Our Ref: HE551519-ATK-GEN-LN-XM-000011

10 March 2021

M25 junction 28 improvement scheme
Planning Inspectorate reference: TR010029
Notification of intention to make a request for additional changes to the
Scheme (Changes 5-7)

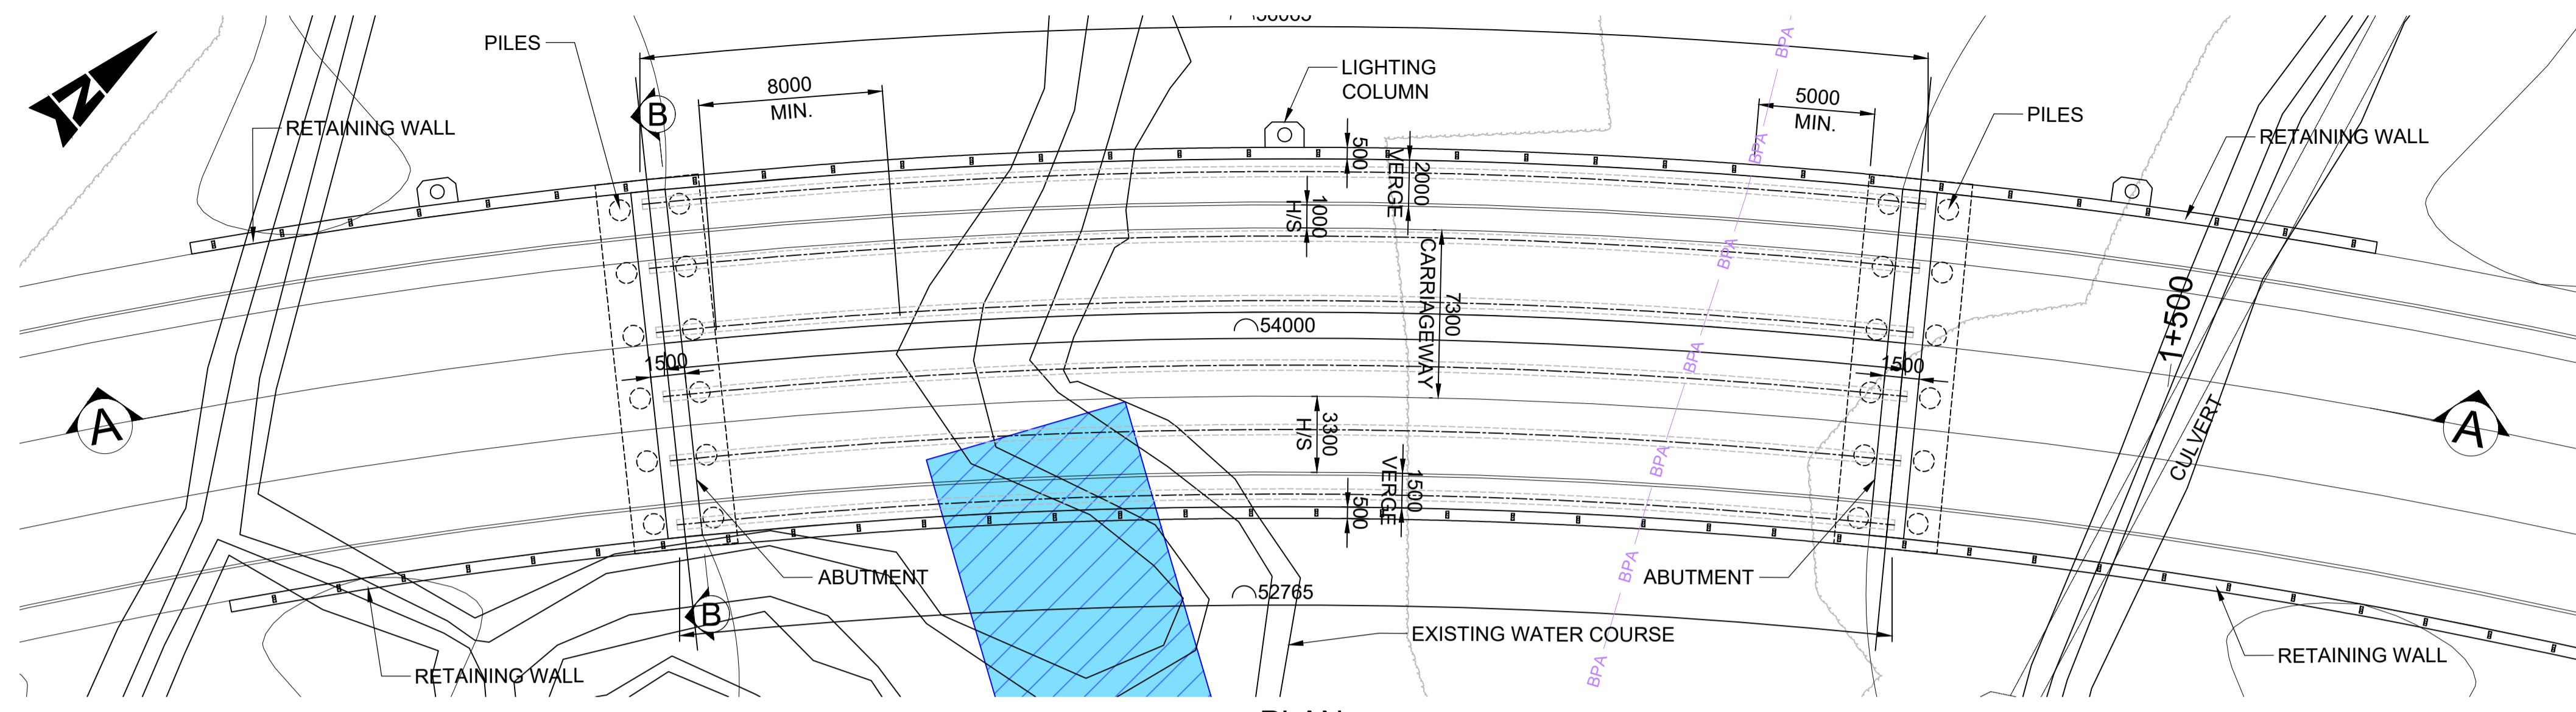
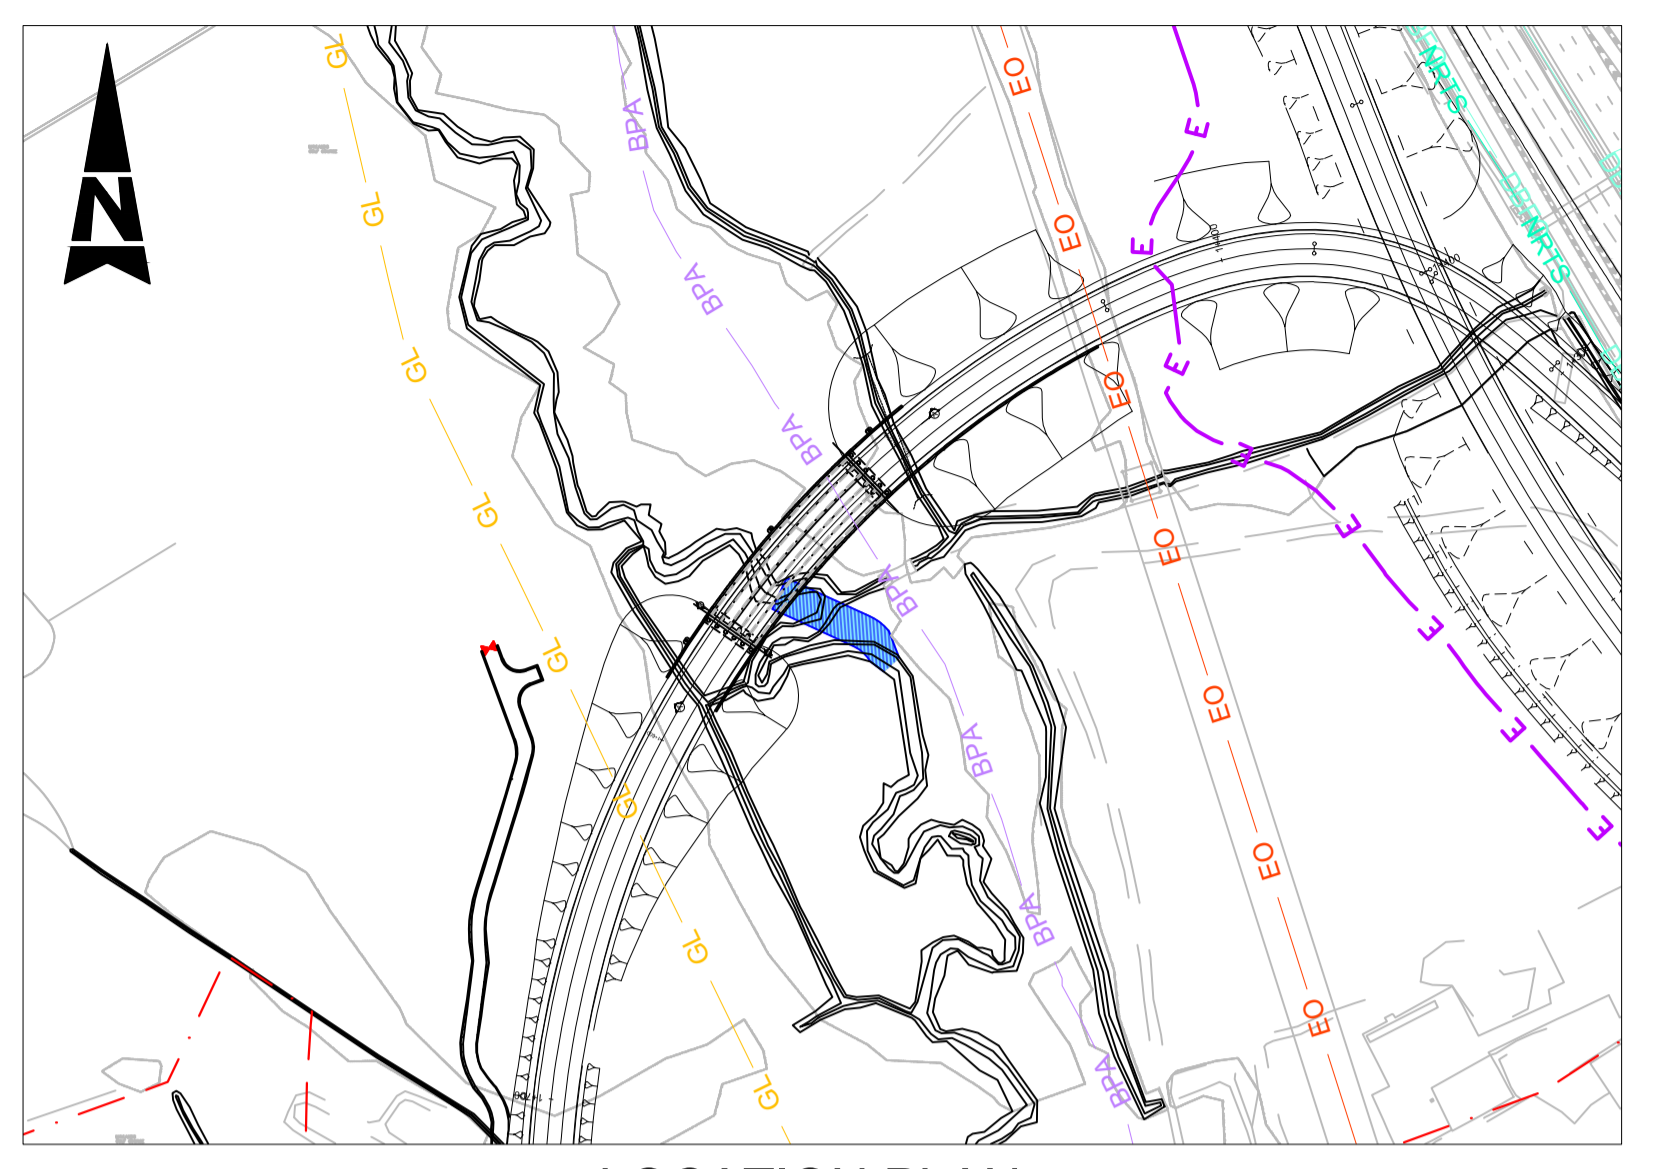
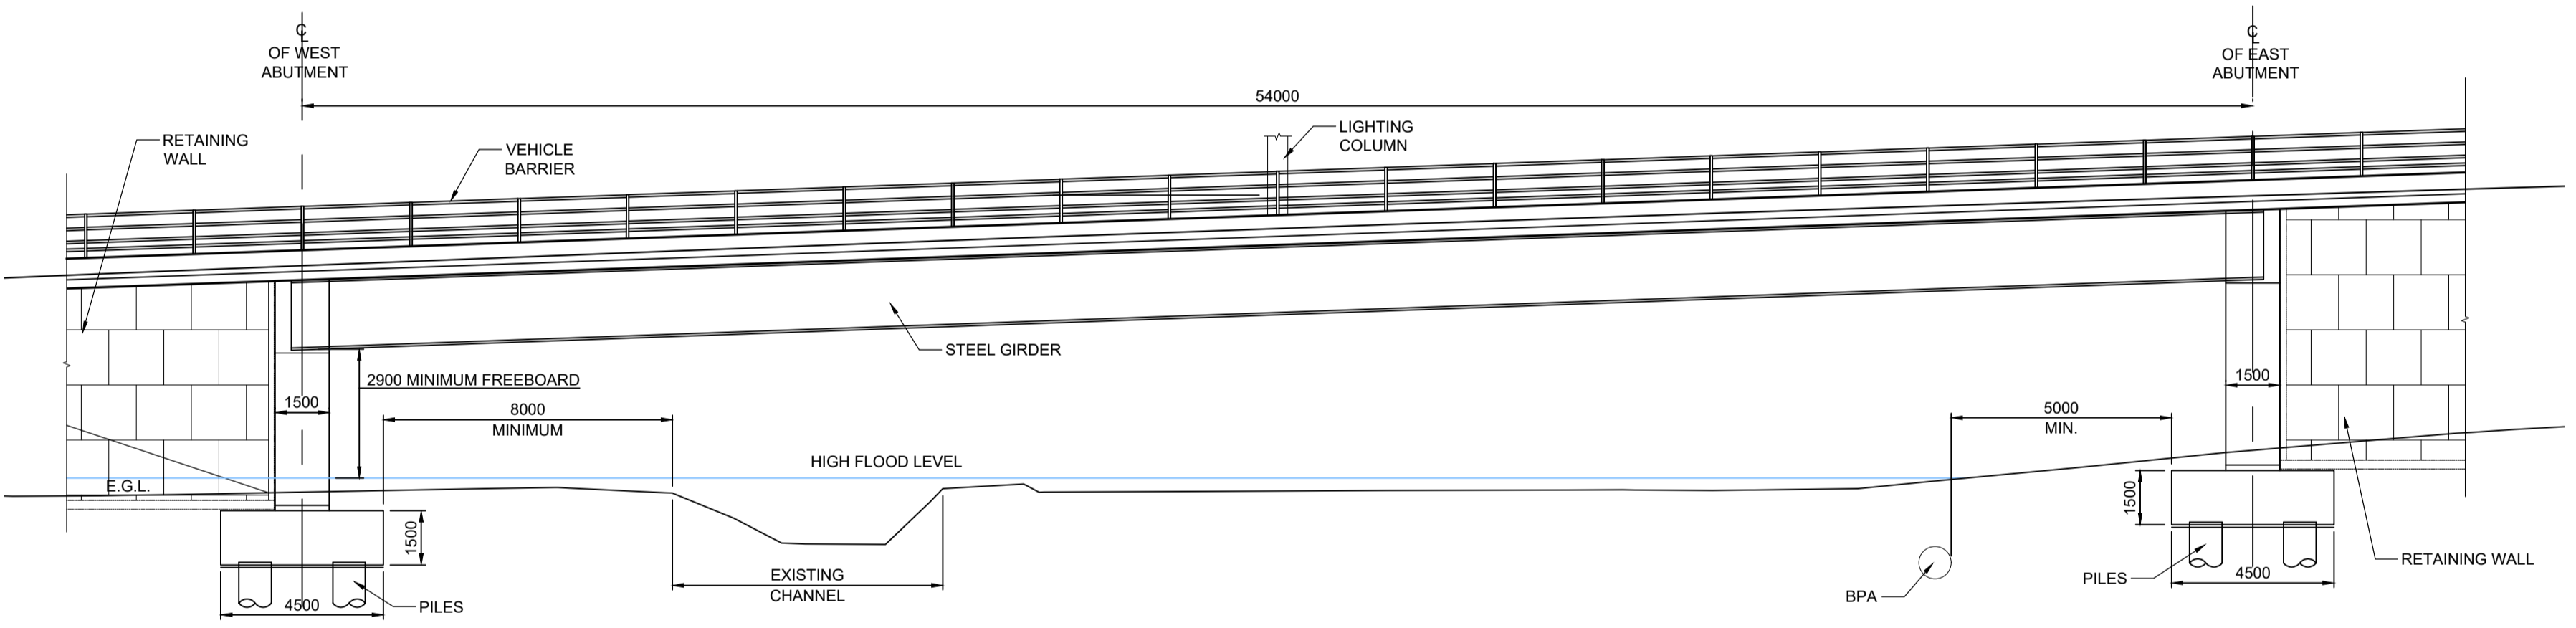
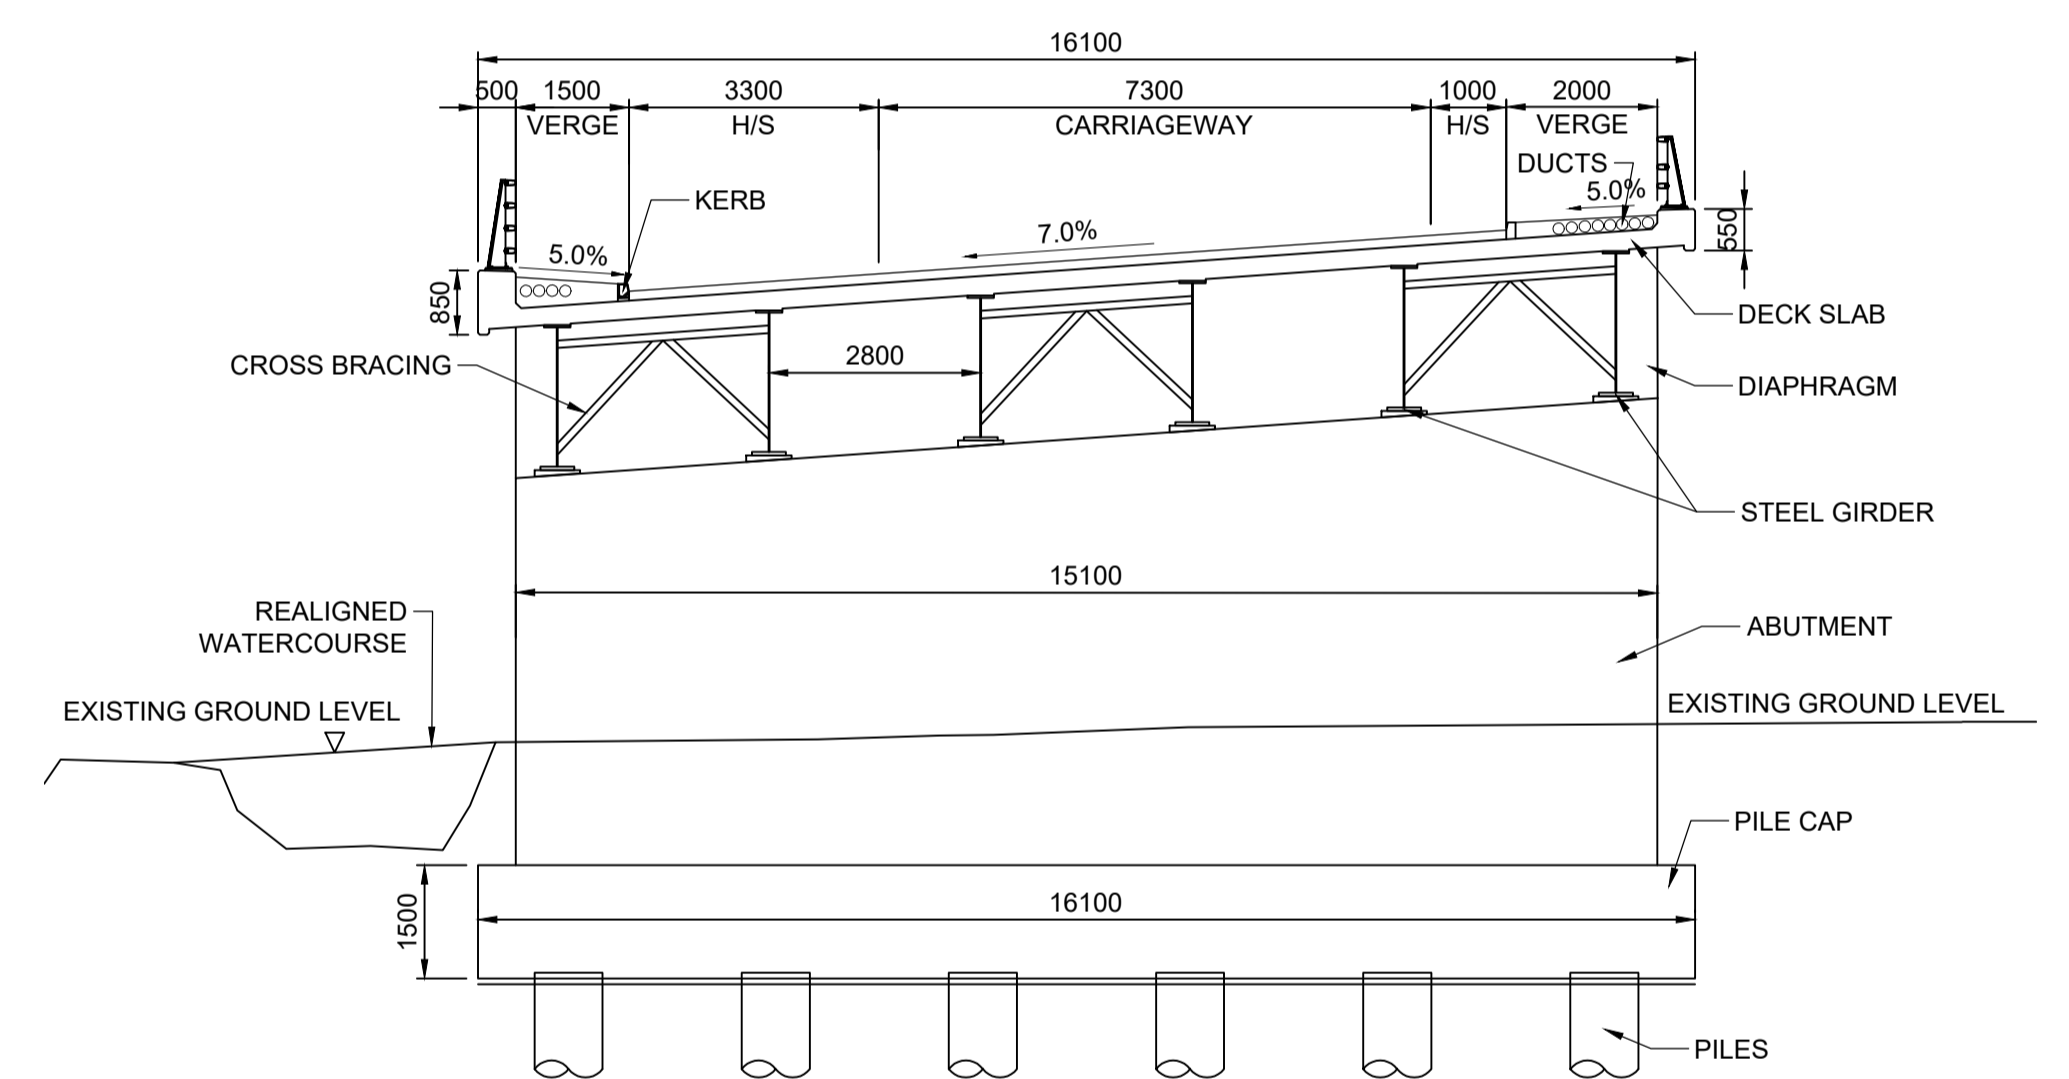
Change 5 – Reduction to the realignment of the Weald Brook (Work No. 23C)

This change would reduce the length of straightening of the Weald Brook from approximately 70 metres to 40 metres. Realignment (straightening) of the Weald Brook is required due to the construction of the new loop road (Work No. 6),

including a new bridge, 'Duck Wood bridge' (Work No. 6C) which will carry the new loop road over the Weald Brook.

The original design for Duck Wood bridge was a two-span bridge with a central supporting pier which resulted in the need to realign a stretch of the Weald Brook (Work No. 23C). As a result of design development, revisions are proposed to the design of the bridge, including removal of the central supporting pier, meaning that the extent of realignment of the Weald Brook is reduced.
